Your Reference: TR030003
**Our Planning Inspectorate
Reference:** 20010091
Our Internal Reference:
DCO/2017/00001

22 May 2018

**RE: TILBURY2 – SECTION 89 AND THE INFRASTRUCTURE PLANNING
(EXAMINATION RPROCEDURE) RULES 2010: EXAMINING AUTHORITY’S “RULE 8
LETTER”**

REVISED SHEET 3 OF THE WORKS
PLANS

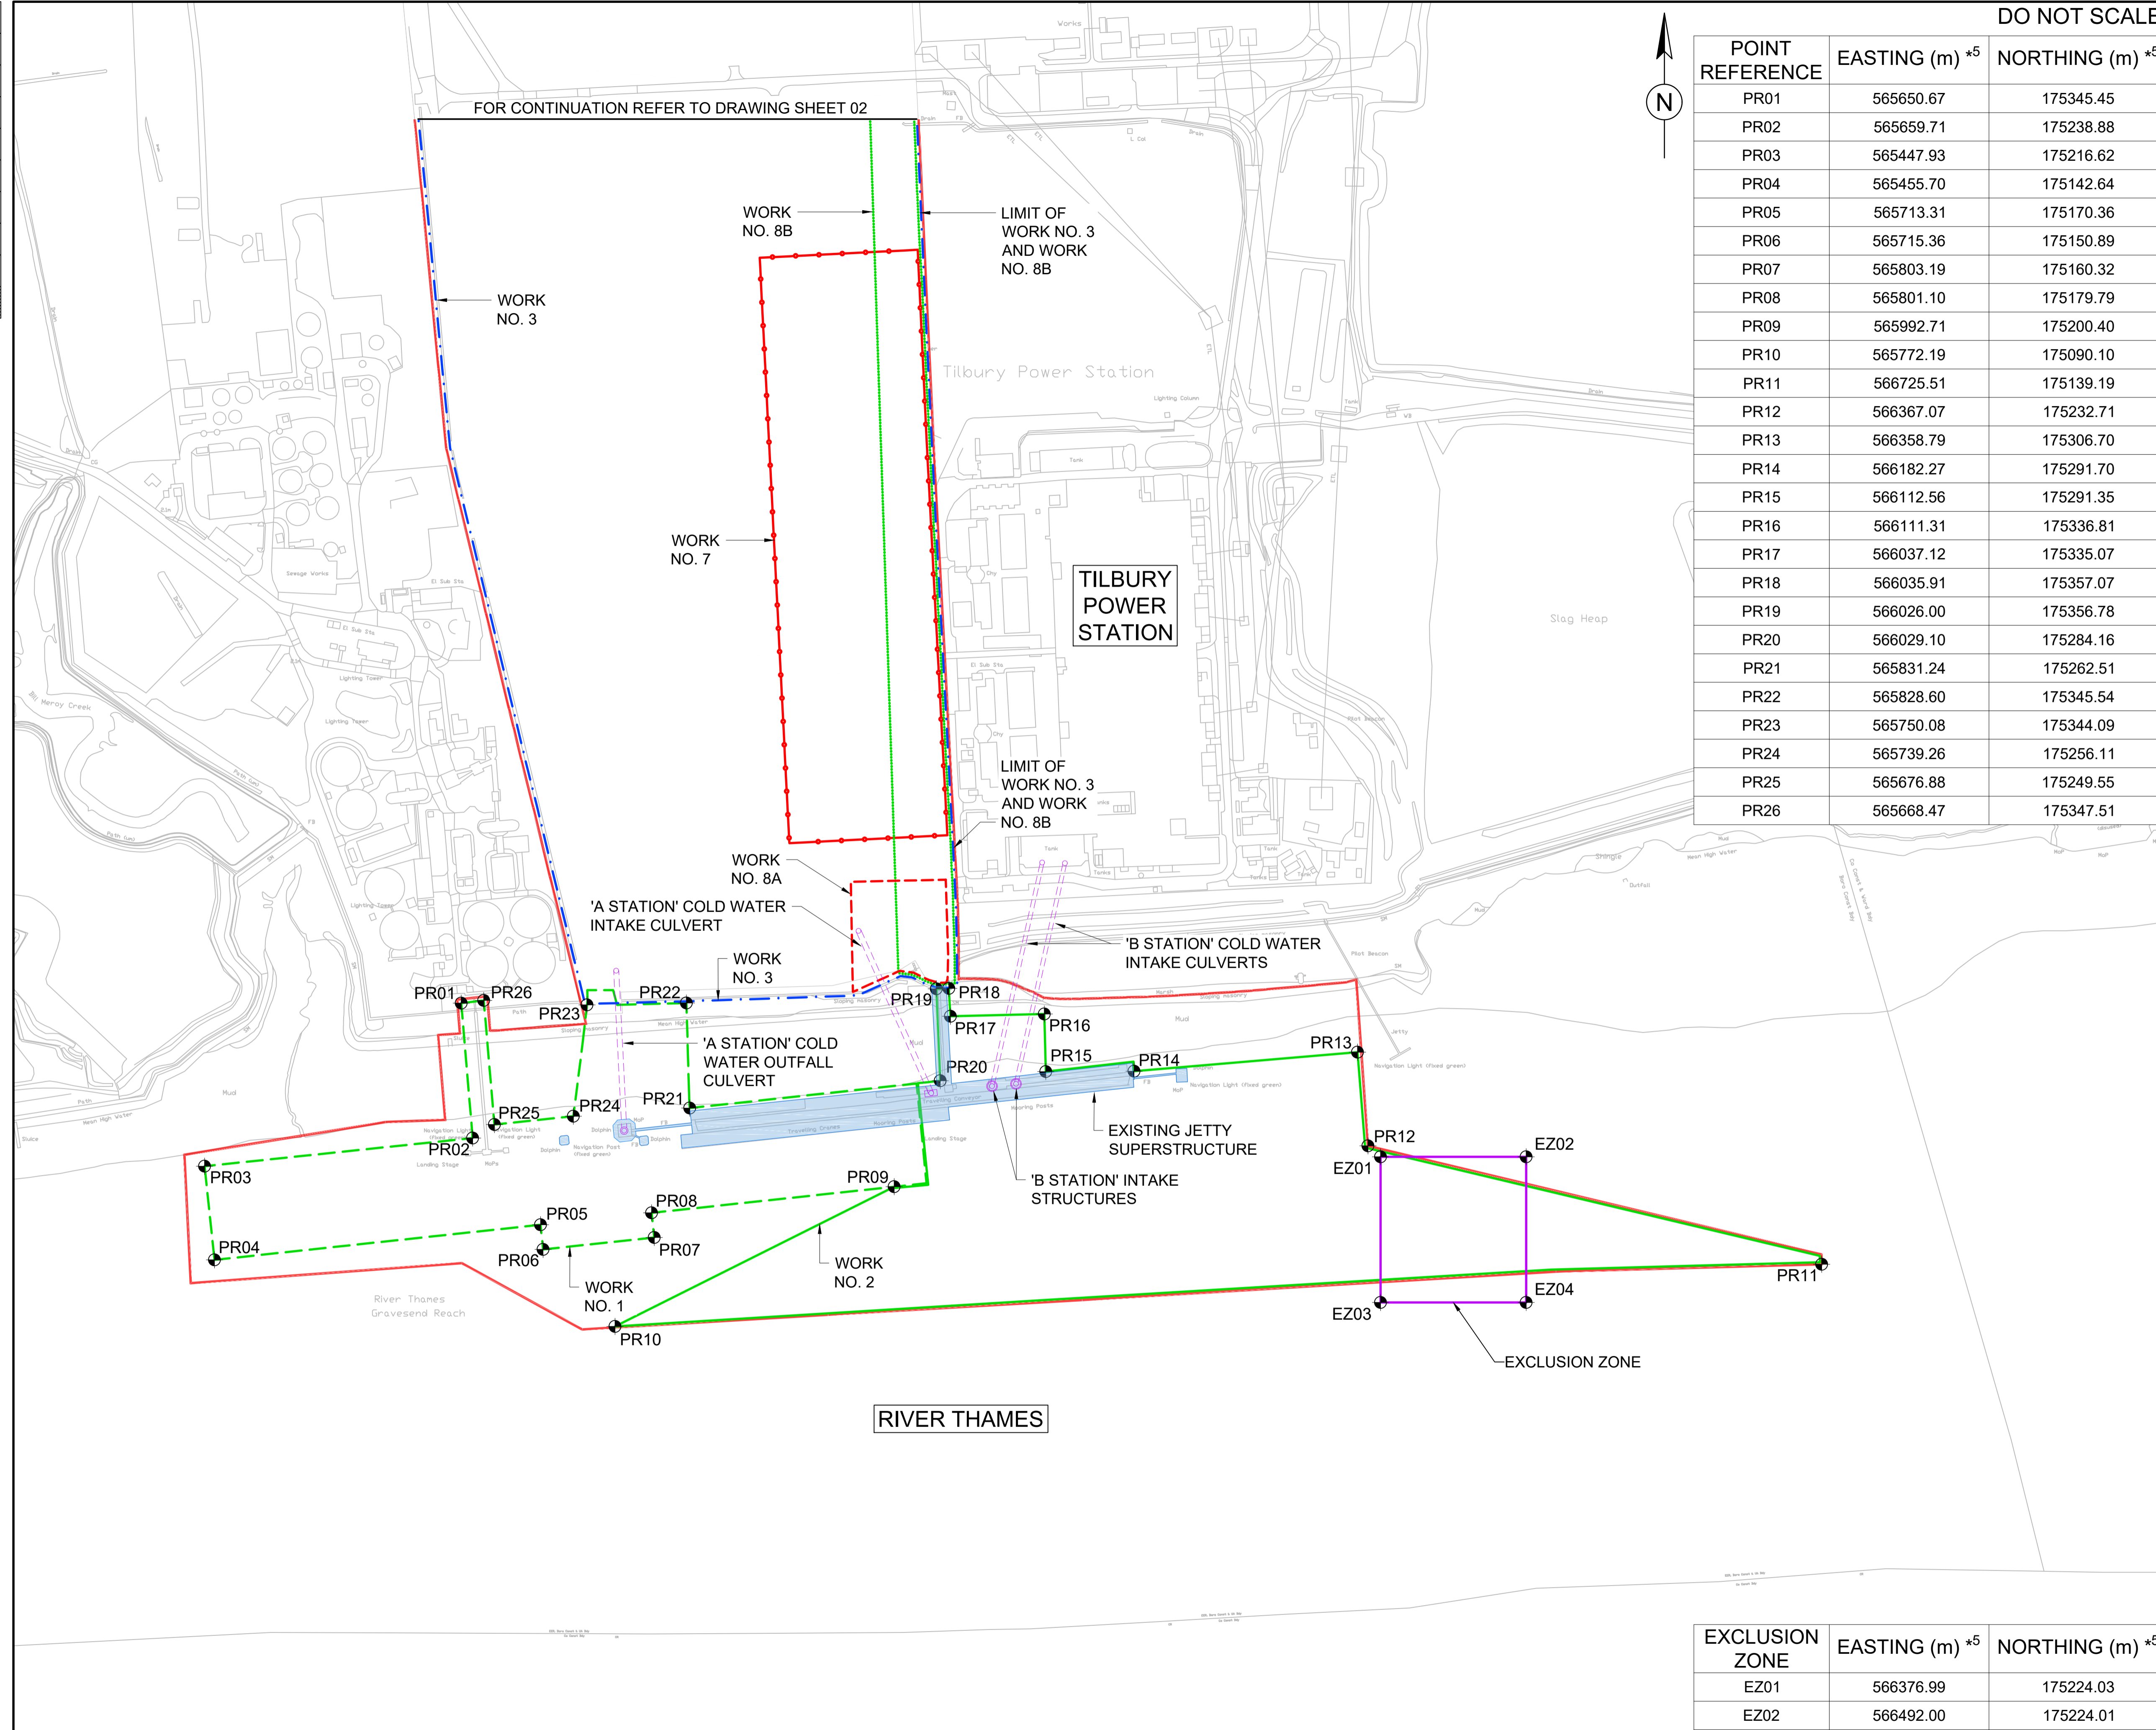
2.4.1. The MMO note that the exclusion zone co-ordinates are still in a form where they lie outside the red line boundary, this should be updated in the next revision in order to fit with the red line boundary.
